From: Peter Cleveland
Sent: 23 July 2010 16:06
To: Planning.Responses
Subject: FW: R/159/10

From: Geoff Bond
Sent: 23 July 2010 16:03
To: Peter Cleveland
Subject: R/159/10

I have been asked to comment on the recent amended plans for the above restaurant and would refer to my previous comments passed to the case officer on 10 May 2010, these are:

EXISTING GROUND FLOOR PLAN 1:100

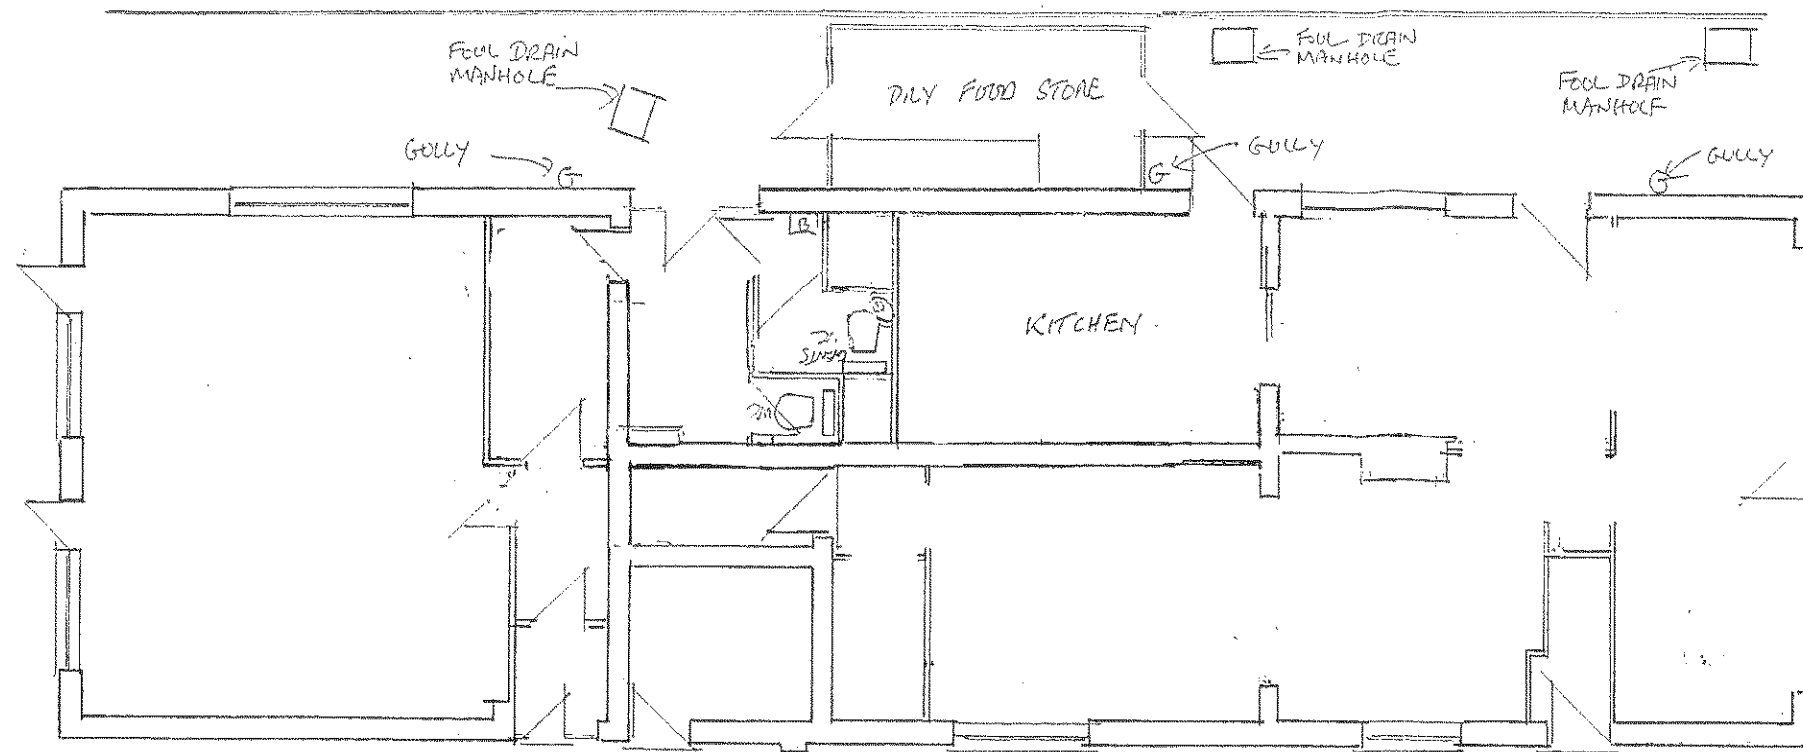
'I have no objection to the proposed extension, which is to be constructed of appropriate materials for use in connection with the main kitchen area. I have noted the relocation of the sanitary accommodation for staff & customers, and advise that the numbers of these facilities must not be reduced in view of the anticipated increased capacity for seated customers in the dining area'.

PROPOSED GROUND FLOOR PLAN 1:100

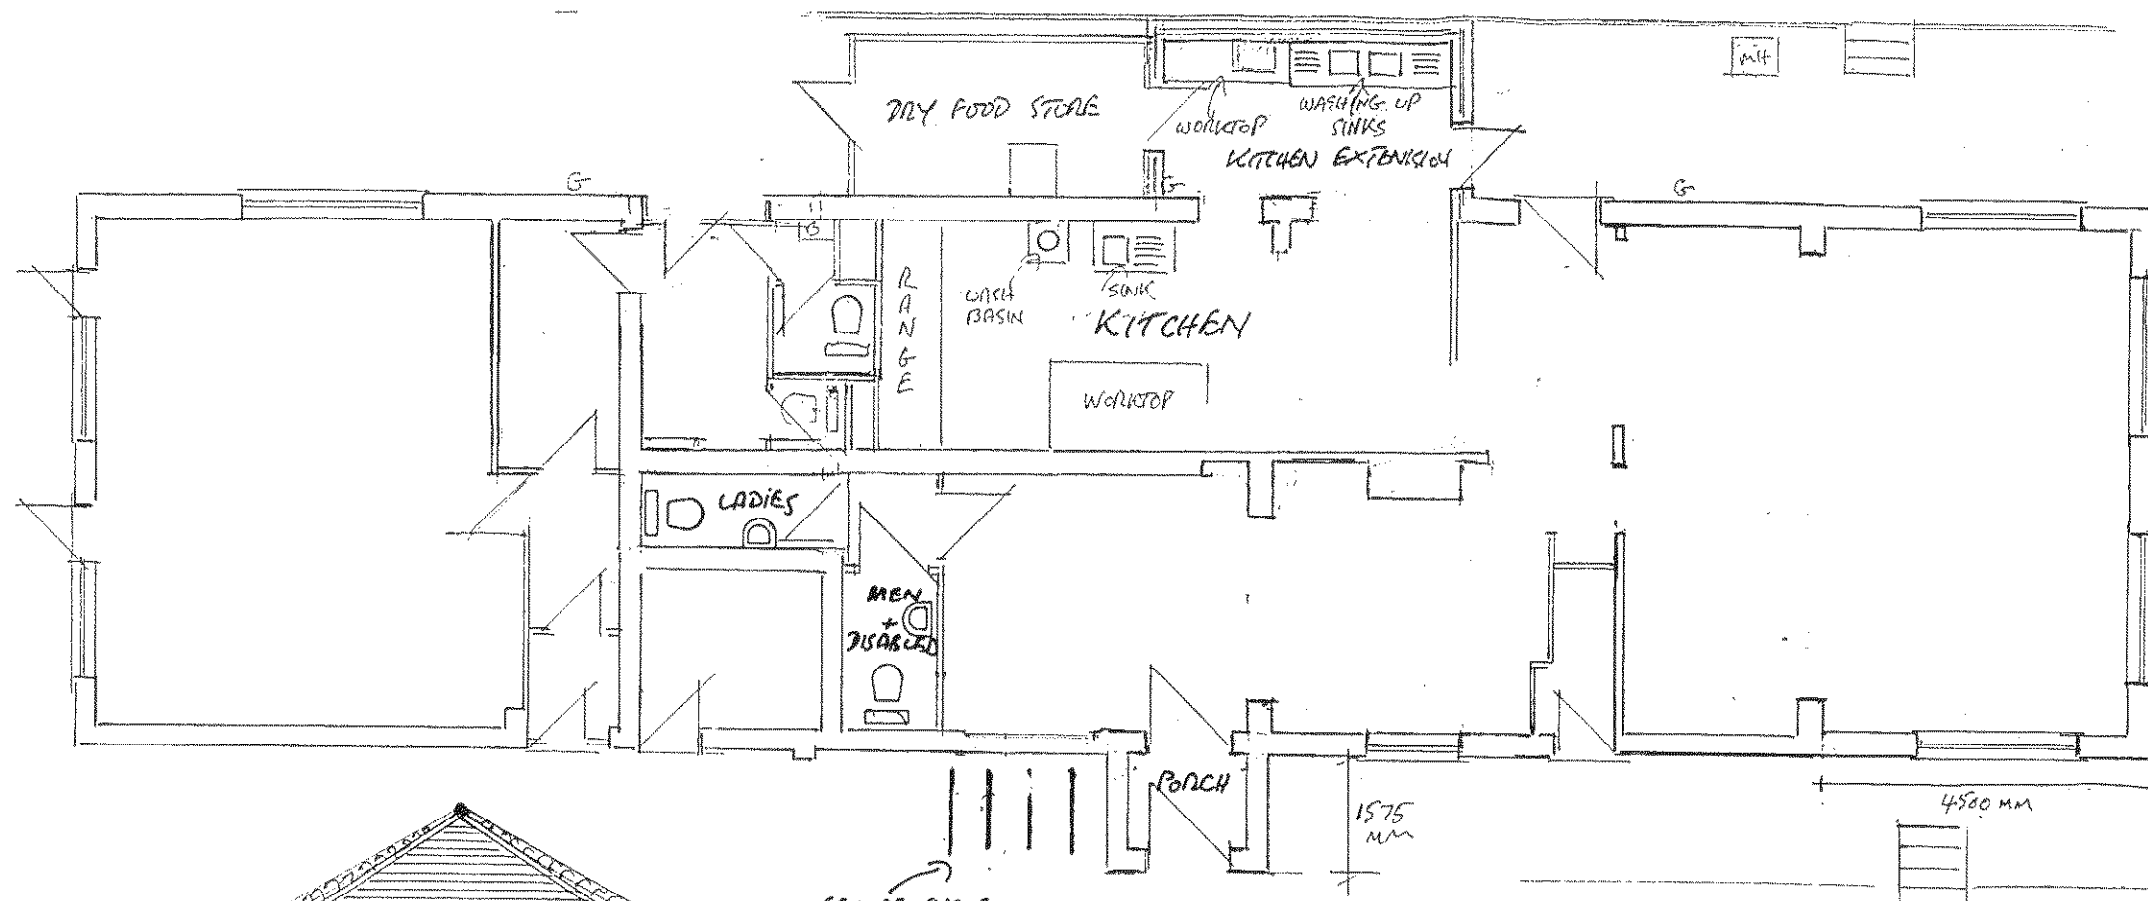
However, the amended plan clearly illustrate a reduction to the numbers of sanitary appliances accessible to customers who are to consume food and drink at these food premises. This proposal is not in compliance with the standards adopted by this authority and in accordance with the Local Government (Miscellaneous Provisions) Act 1976, therefore, I have to object to the proposal.
